ACP: 322154-25
Planning Authority Ref: 2560003

An Bord Pleanála Planning Reference	ABP-322154-25
KCC Planning File	256003
Name	Briskalagh Ltd.
Address	In the townlands of Acragar, Ballyconra, Ballycuddihy, Ballyroe, Ballyroe (Grace), Ballyroe (Maher), Baunaniska, Boherkyle, Briskalagh, Brittas, Clone, Coolnapisha, Curraghduff, Freshford, Freshford Lots, Graigueswood, Grange, Huntstown, Kilmanagh, Knockeenglass, Knockown, Moatpark, Monabrika, Monavadaroe, Moneenaun, Oldtown, Oldtownhill, Parksgrove, Picketstown, Rathealy, Sart, Sweethill, Tobernapeastia, Tullaroan, Upperwood Demesne, Co. Kilkenny.

1. Purpose of this Submission

Figure 31. Kilmanagh town Tullaroan Stream longitudinal profile and two cross sections showing water levels in the river channel for Existing and Design River System for Q_{100cc} .

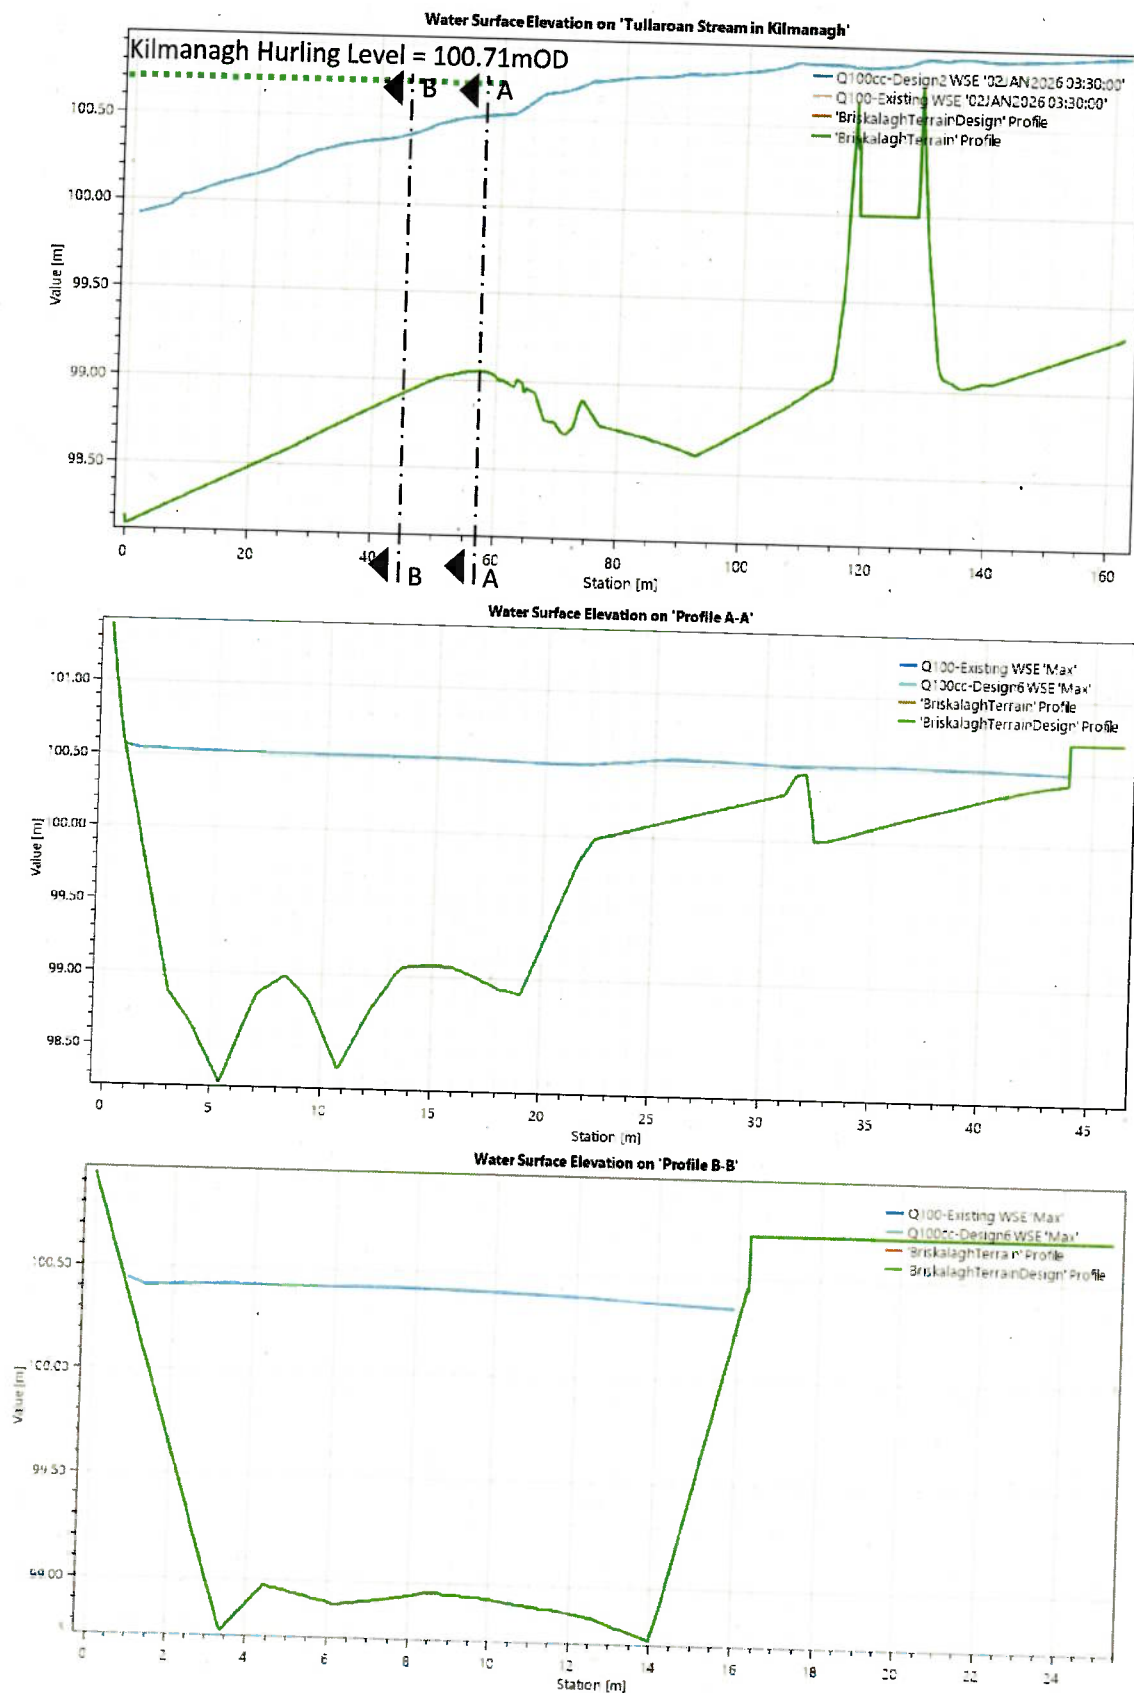
We note the Fluvio R&D Limited report, submitted as part of the appellants Further Information response. Our initial review of this new document finds serious and multiple erroneous statements. One such example can be found on page 50 of the Fluvio R&D Limited report which states that special attention was given to flood levels in Kilmanagh village. In particular, and as highlighted in Figures 33 & 34 of the report, it is explicitly stated that during the occurrence of a Q100cc (1 in 100 year + climate change) or a Q1000cc (1 in 1000 year + climate change) the output of the hydraulic modelling exercise demonstrates that the hurling pitch immediately downstream of Kilmanagh bridge does not flood. **This is a significant and concerning erroneous statement and miscalculation.**

The hurling pitch at this location is known to be subject to flood inundation on a regular basis. Figure 1 below illustrates the hurling pitch following one of three flood events in October and November 2023. And as recently as 11th November 2025, this flooding recurred at this location once again.

This demonstrates that this Site Specific Hydraulic Modelling exercise is significantly flawed and does not provide any confidence whatsoever in relation to the potential adverse impact of the proposed wind farm development on the existing hydrological regime of the area
